**The Northampton Gateway Rail Freight Interchange Order 201X
Applicant's Response to s.55 checklist: minor errors and omissions**

Drawing Title
HIGHWAY PLANS CROSS SECTIONS SHEET 1 OF 5

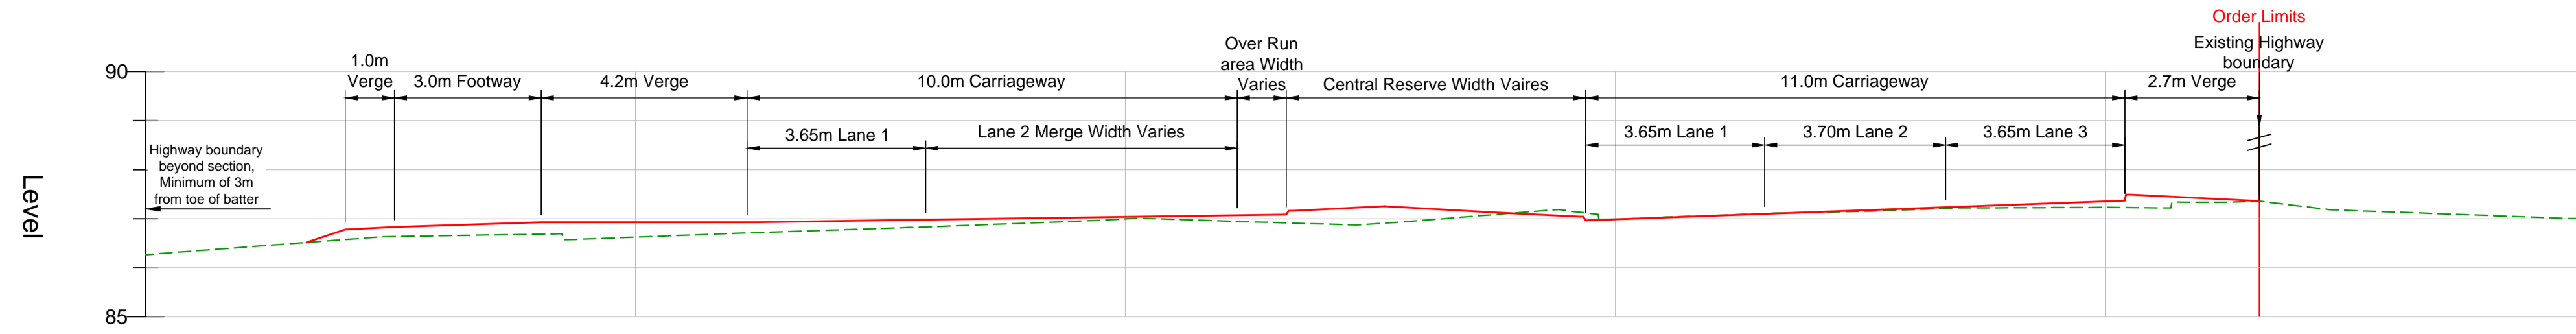
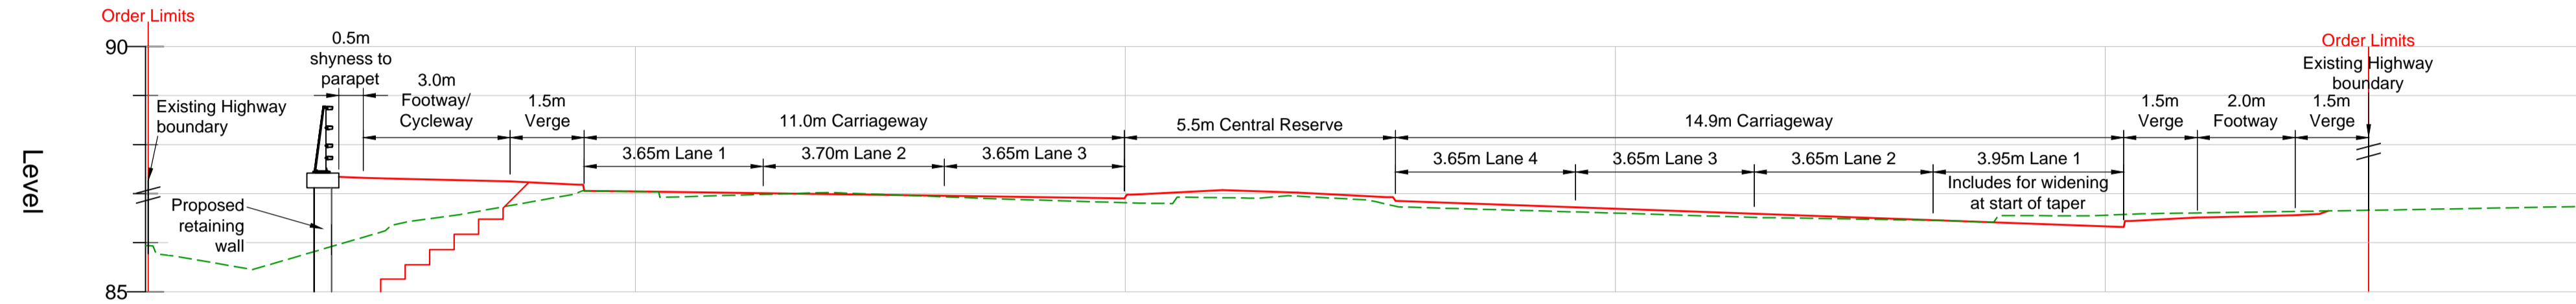
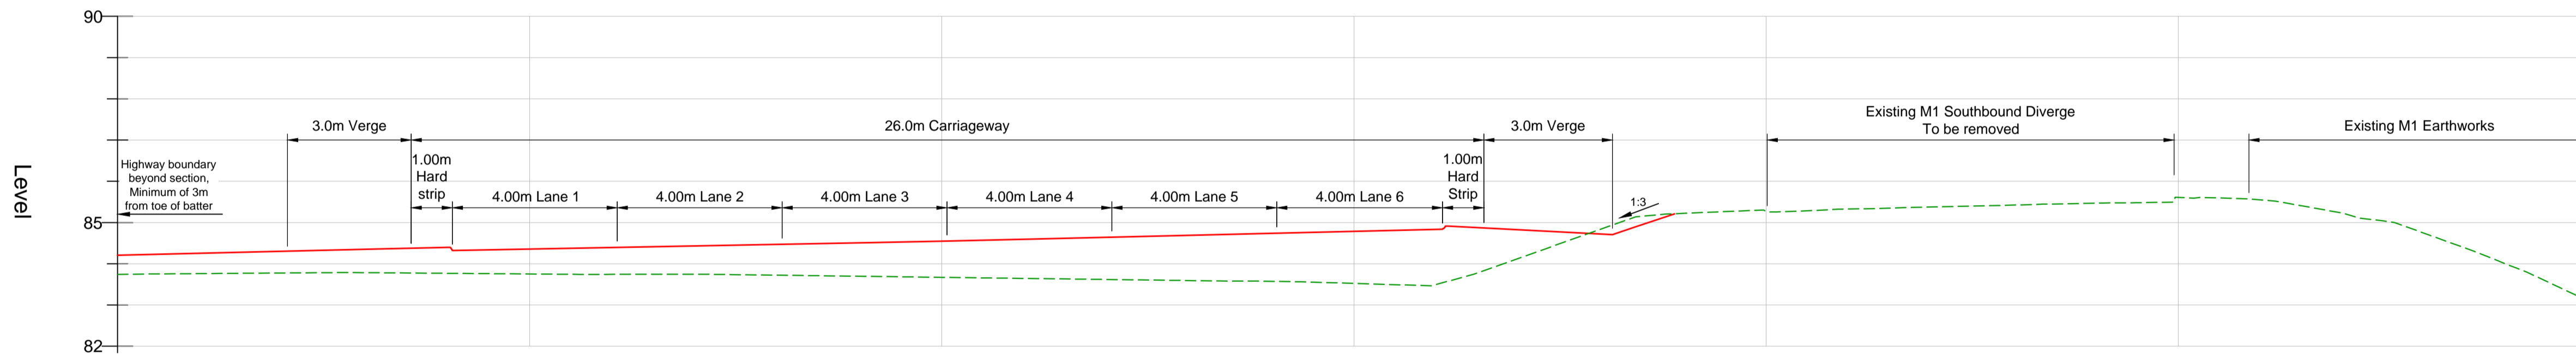
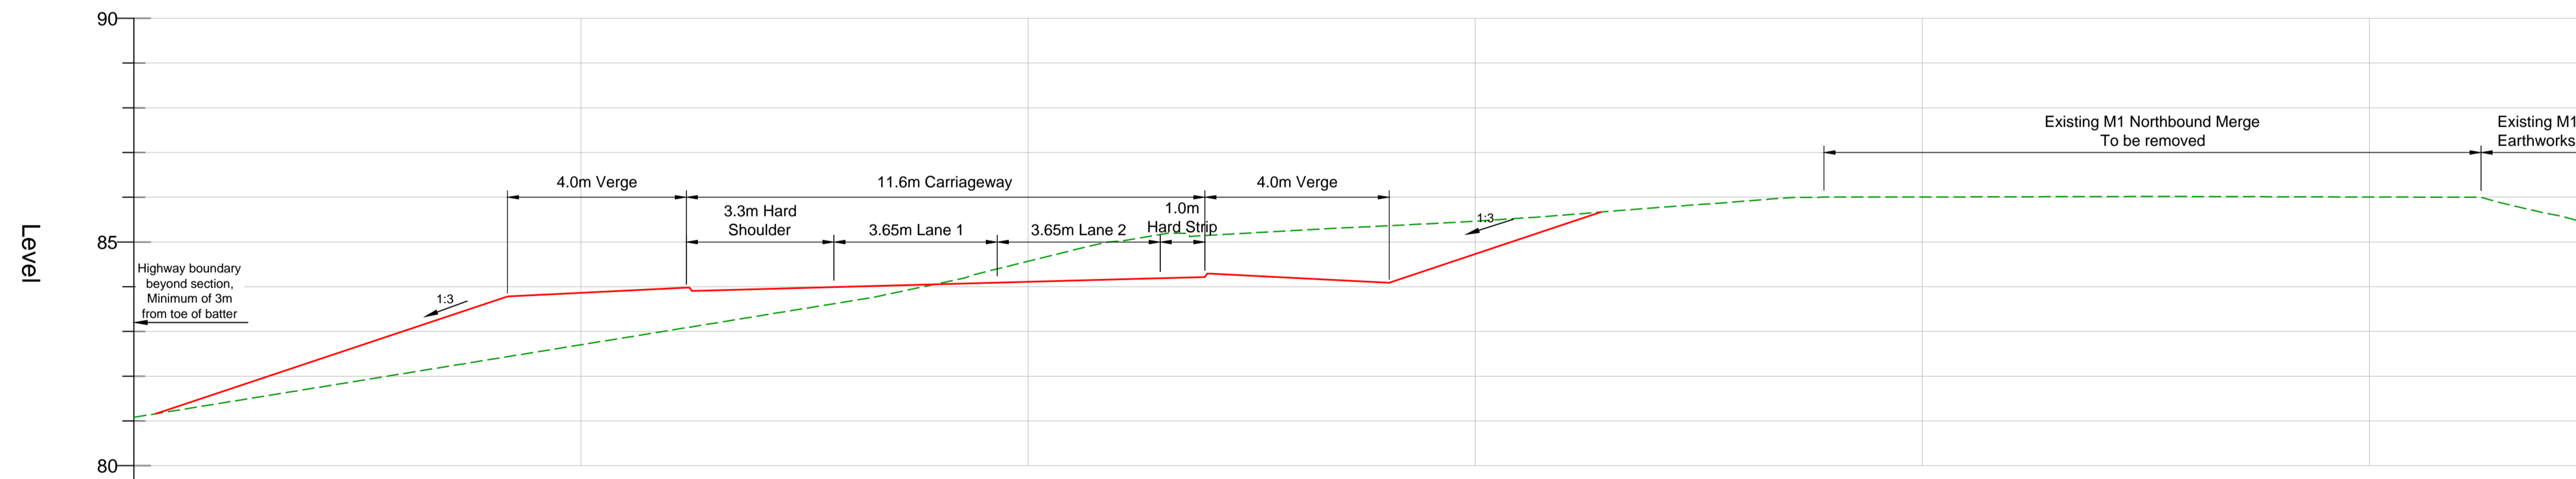
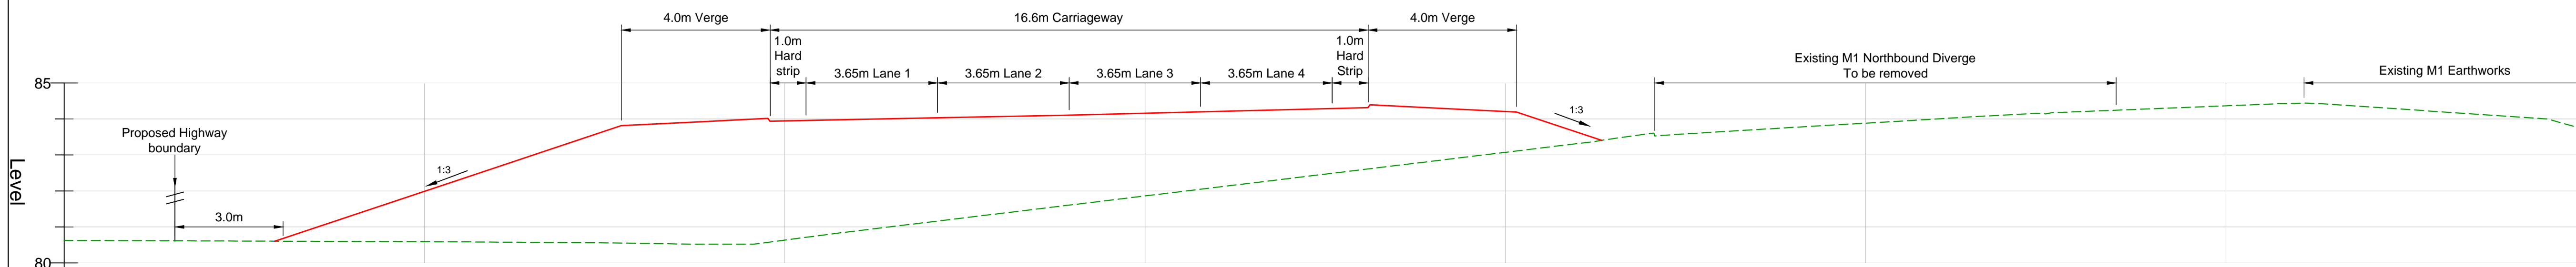
| 30. Are there any observations in respect of the documents provided above? | |
|---|---|
| Cross Sections Plans (Doc 2.4G – 2.4L) don't appear to be consistently drawn to scale. | The highway cross sections are all shown at 1:100 scale, with the exception of sections O and P (Document 2.4K) which are both shown at 1:200 scale (as labeled). |

| 30. Are there any observations in respect of the documents provided above? | |
|--|---|
| | <p>Sections O and P are cross sections of the roundabouts at M1 Junction 15A, that include both sides of the circulatory carriageway, verges and the central island. As a result of the width of the cross section they have been shown at 1:200 such that, the whole roundabout could be shown in one section, rather than splitting the sections into two parts and losing the context of the proposals.</p> <p>The Applicant trusts this explanation is useful but please confirm if amended plans would be helpful.</p> |

Sheet 6 Location Plan (1:50,000)

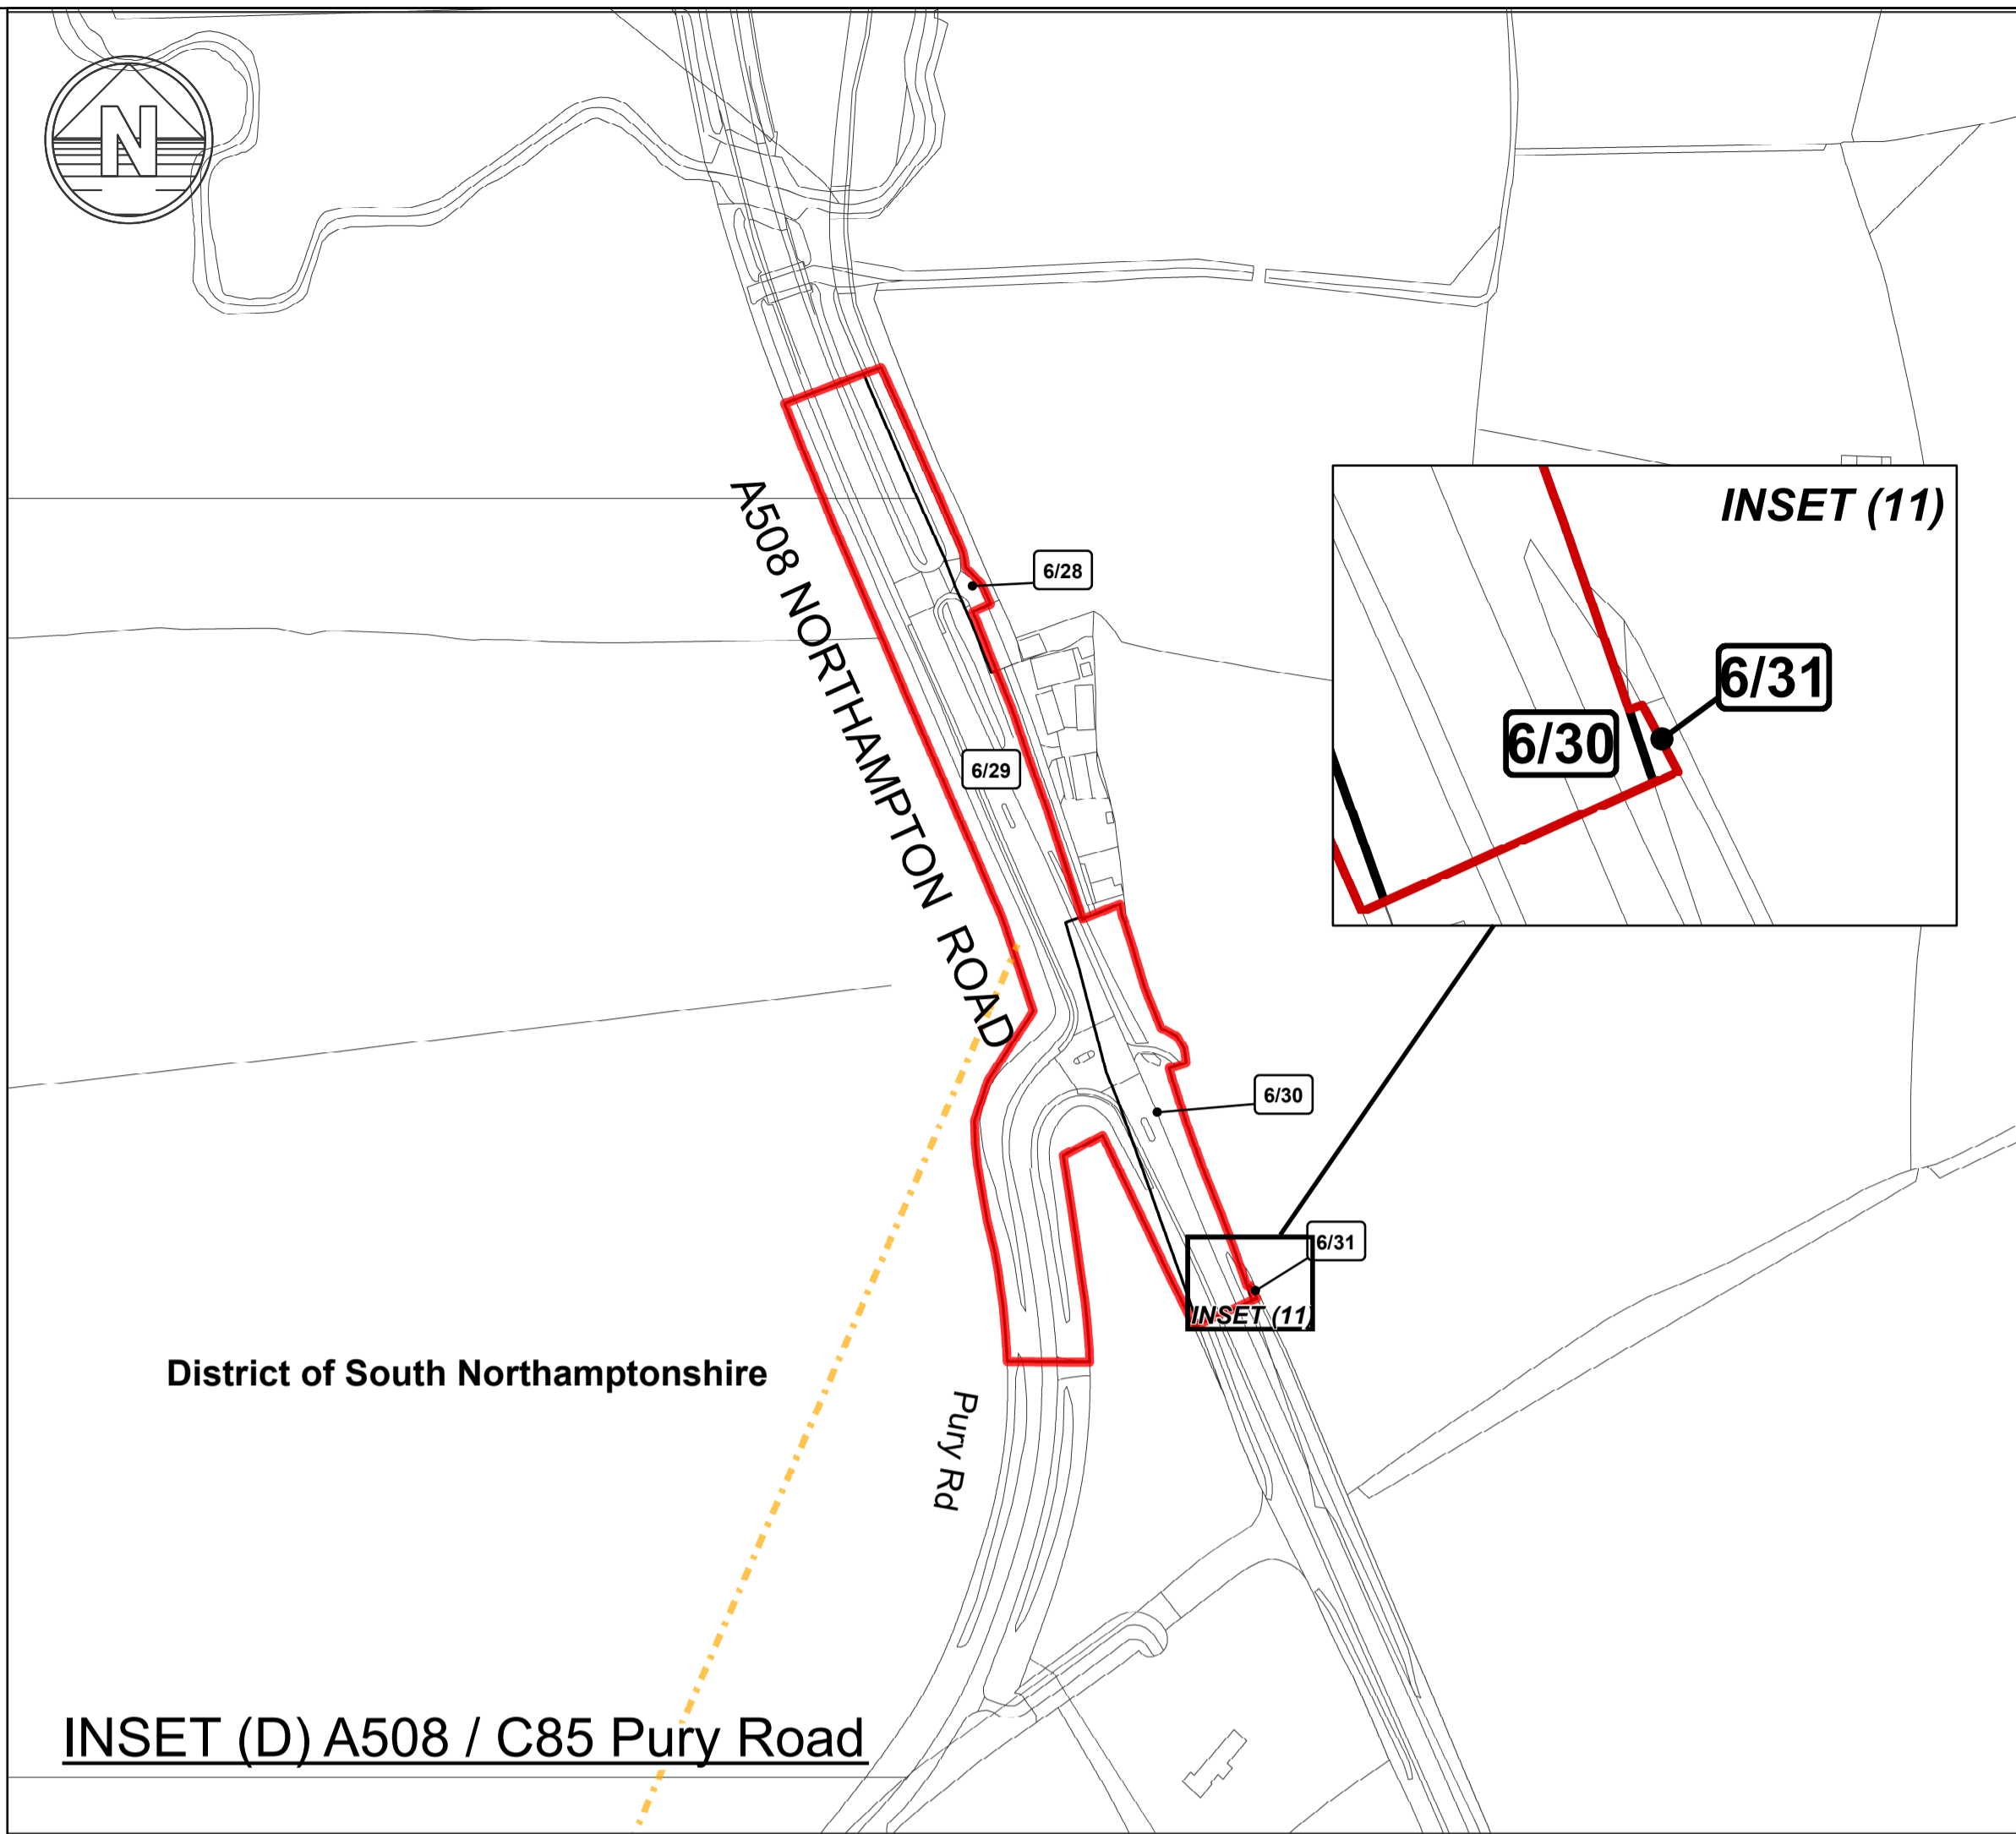
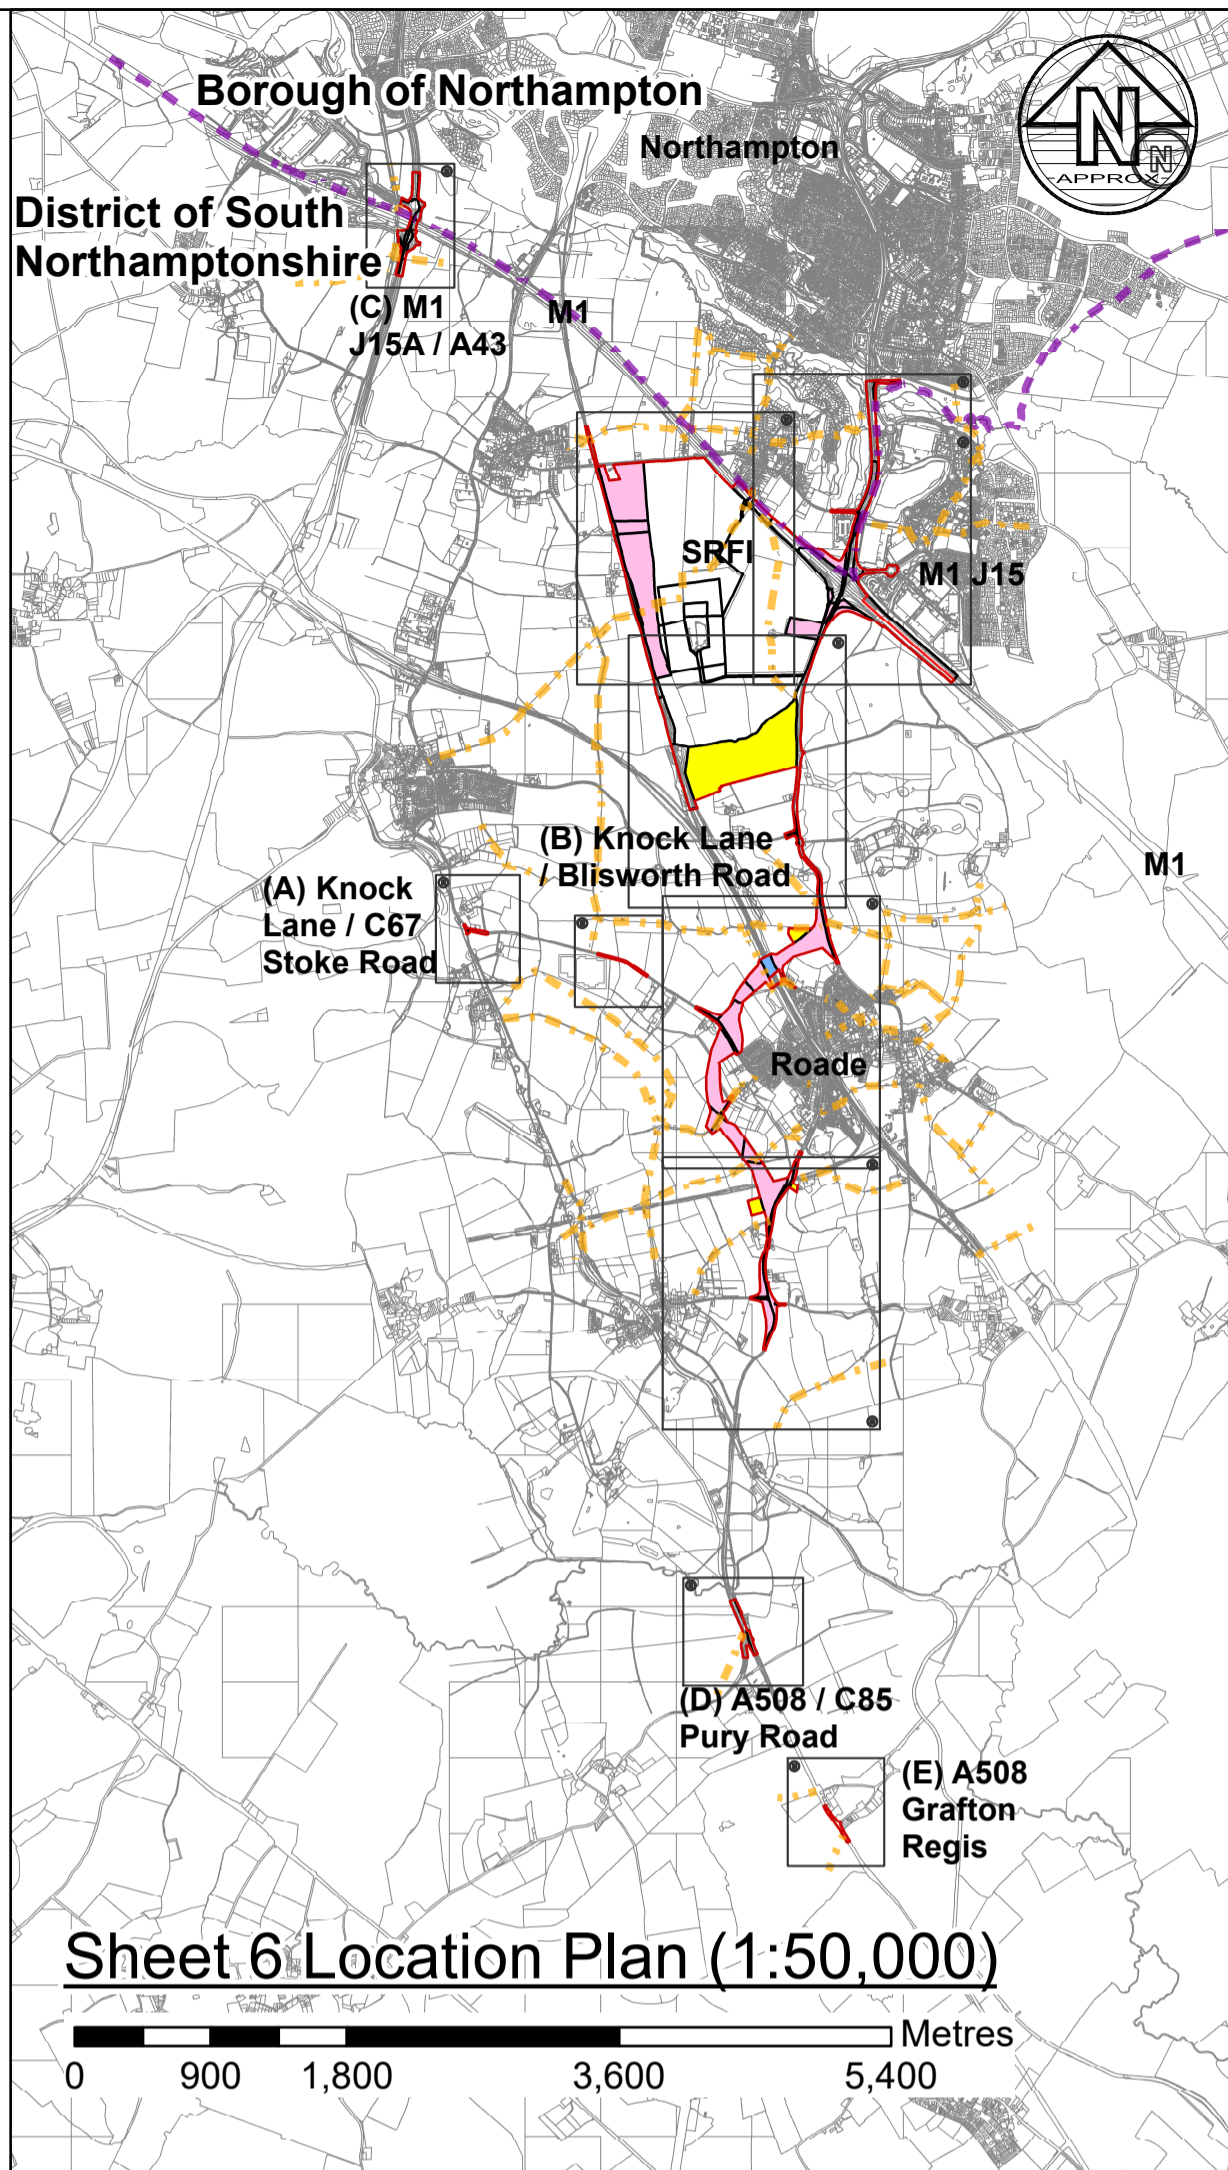
| 30. Are there any observations in respect of the documents provided above? | |
|---|---|
| <p>Land Plans (Doc 2.1A – 2.1F) The following plots on the land plans cannot be seen clearly: 2/29, 6/8, 6/12, 6/15 & 6/16.</p> <p>On Sheet 6 of the Land Plans (Doc 2.1F) the point at which plots 6/5, 6/6, 6/8 & 6/9 meet is unclear.</p> | Updated sheets 2 and 6 (Documents 2.1B and 2.1F) have been prepared with further insets to clarify these small parcels, together with an updated Key Plan (Document 2.1). |
